**CAMPUS
IMPROVEMENT
PROGRAM 2014–2020**
STATE-SIGNIFICANT
DEVELOPMENT
APPLICATION (SSD 13_6123)
SEPTEMBER 2014

SUPPLEMENTARY
RESPONSE TO
SUBMISSIONS

KEY ISSUES - CIP RESPONSE TO 2ND ROUND OF AGENCY SUBMISSIONS SEPTEMBER 2014

Drawing no:	SSD-E-15
Date:	12-09-2014
Drawn by:	CIS
Checked by:	JC

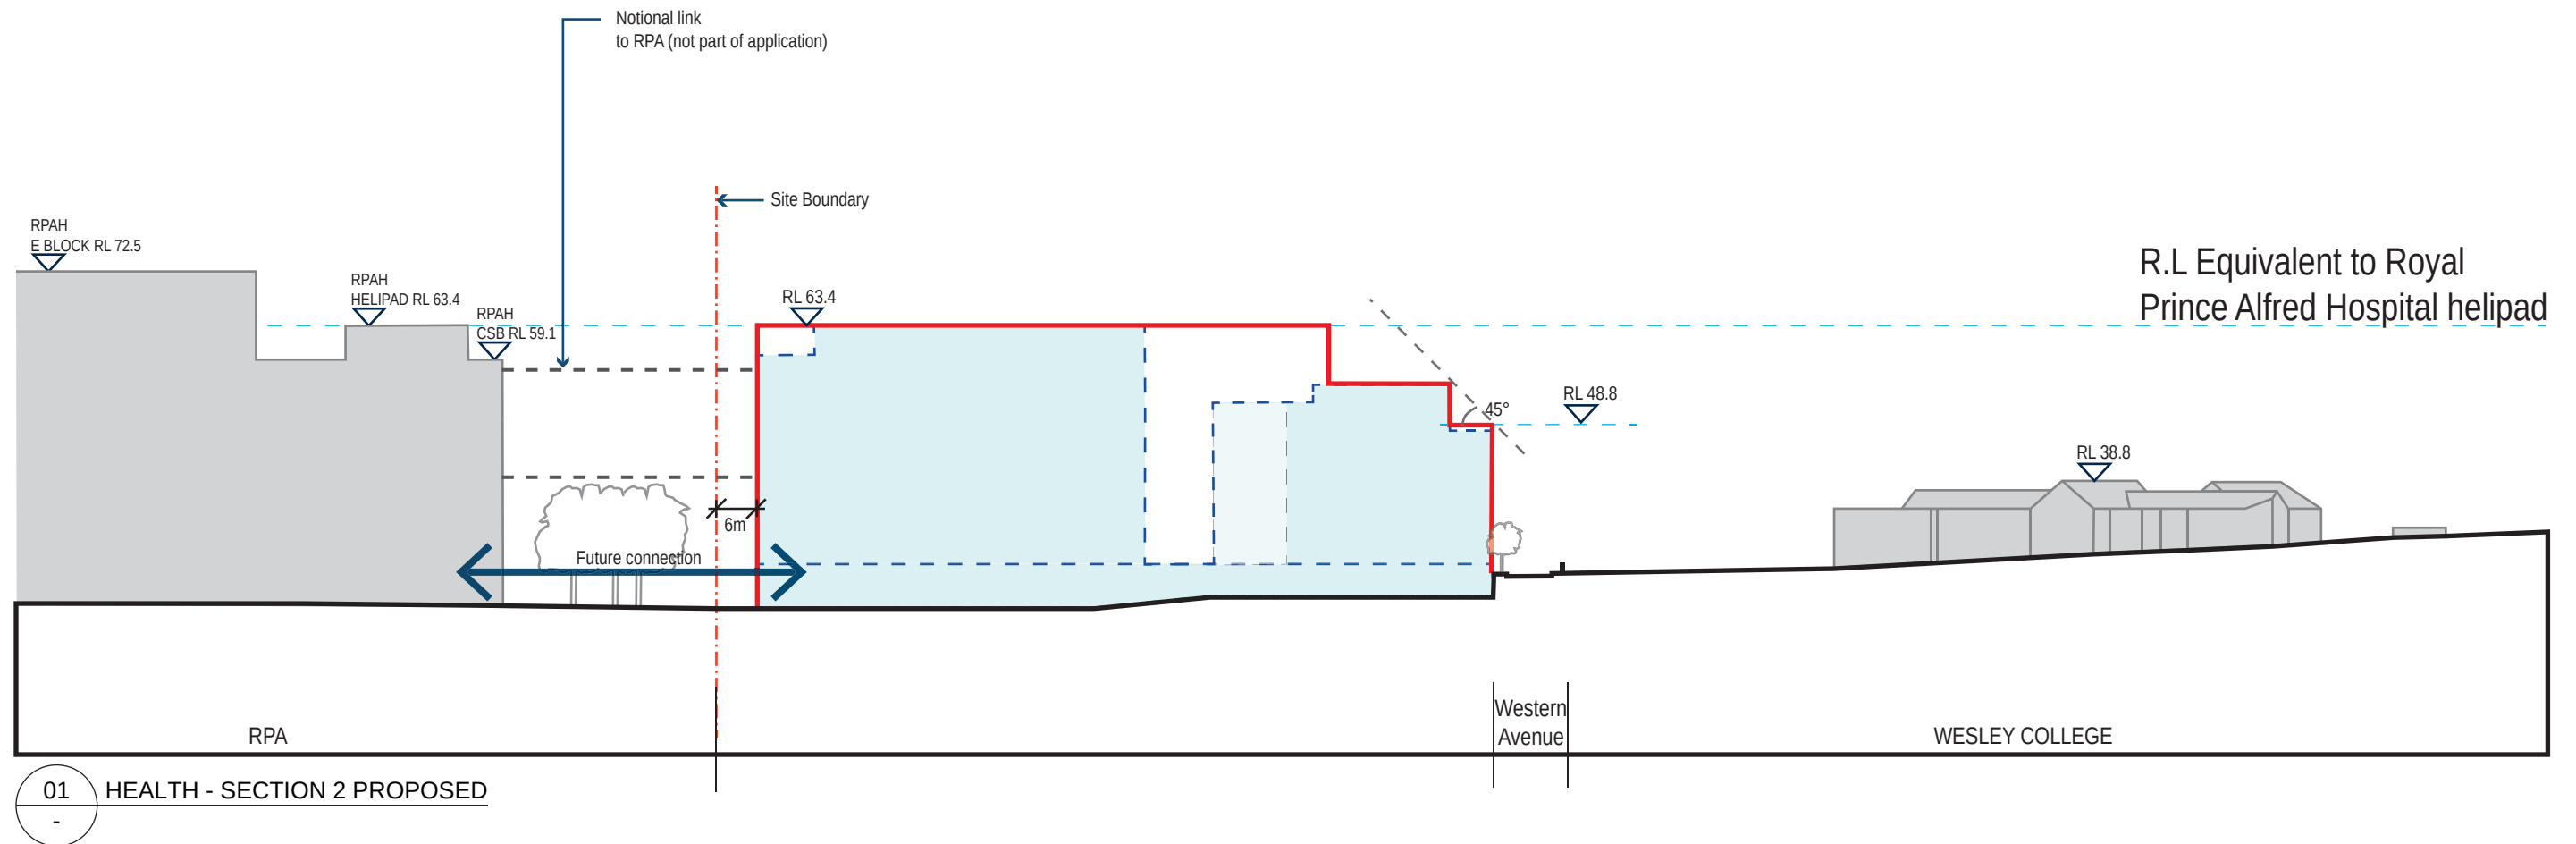
5. HEALTH PRECINCT: Concern with Health Precinct envelope and footprint (SLHD): - Height is not commensurate with RPAH building height. The height does equate to the RPAH height fronting Missenden Road RL72.5; however this height drops down to RL63.4 to the rear (east) where helipad is present. - Building setbacks recommended from the common boundary between RPAH and University. Although not dimensioned, these appear to be about 10-12 metre setbacks. This is driven	Agreed – Amended Plan SSD-E-11, 12, 13, 14, 15 & 16: On 11 September 2014, the University and SLHD met to discuss issues raised in the SLHD submission. The meeting resolved to agree on a number of CIP Health Precinct building envelope revisions. Agreed amendments to the CIP Health Precinct include the following (refer to drawings SSD-E-11 to16):

ISSUE	THE UNIVERSITY OF SYDNEY- CIP RESPONSE
by a notional future RPAH Inpatients Extension building which would be built close to the University boundary.	1. The Health precinct building footprint is to be set back from all RPAH eastern boundaries with University land by a minimum of 6m. 2. The height of the building envelope will be reduced from RL 72.5 to RL 63.4 which equates to the RL height of the RPAH Helipad. 3. The section marked “<i>notional link to RPAH (not part of application)</i>” (plan SSD-E-13) reflects the potential for RPAH and the University sites to connect respective buildings.
 Health Precinct Section fronting Cadigal Lane	
Shadows falling on Gloucester House and future Inpatient building (SLHD).	Shadow plans (already submitted) demonstrate additional mid-winter shadows to façade Gloucester House at 9am, and will cease by latest at 11am. At mid-winter noon, additional shadows will fall on the service lane that separates RPAH from the Blackburn and Bosch buildings. The CIP Health Precinct shadow plans demonstrate satisfactory levels existing and additional mid-winter solar access on all surrounding land, and comply with the City of Sydney DCP solar access requirements.
